Application number: 2026/62/91628/W
Applicant Jones Homes (Yorkshire) Ltd
Objection - recommend refusal of the planning application 2026/62/91628/W

Reply to initial planning application: 2026/62/91628/W

Site address: land off, Boshaw View, Hade Edge, Holmfirth, HD9 2TZ

Objection - Recommendation for refusal of the application 2026/62/91628/W

323 Dunford Road, Hade Edge
Window Sampling Borehole and Trial Pit Locations

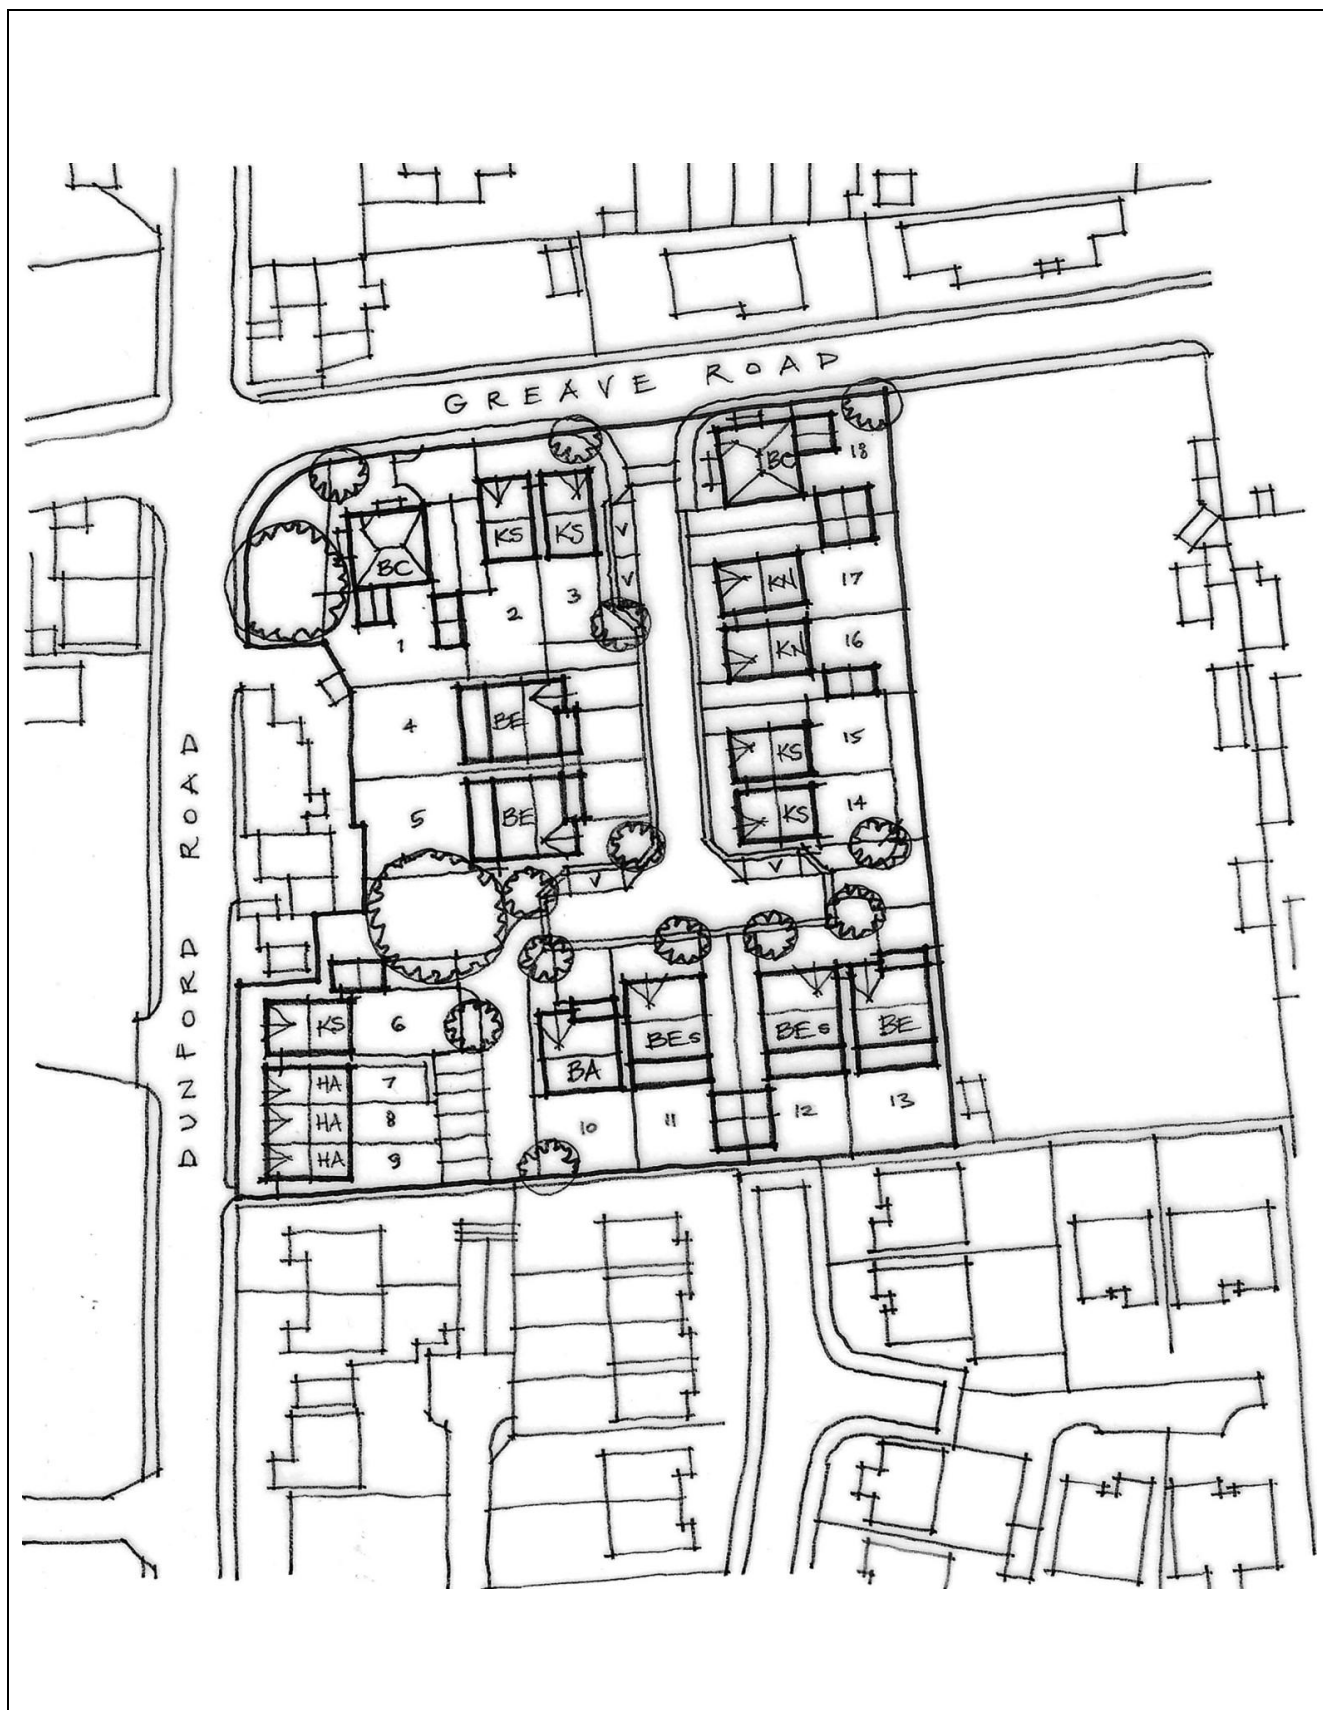
Phase One Geoenvironmental Risk Assessment and Phase Two Ground Investigation Part 1 - page 56 Window Sampling Borehole and Trial Pit Locations

My client has told me of mechanical excavations beneath tree **T3** in 2025, which he thought would be illegal given the TPO's on the trees. When reading through the information in this document, it appears that these were as a result of the Geotechnical and Geoenvironmental Consultants undertaking borehole samples. The map below shows these locations. There are also photos of the digger on the site. It is clear that TP13 (Trial Pit 13) would have taken place beneath the canopy of **T3** as my client witnessed.
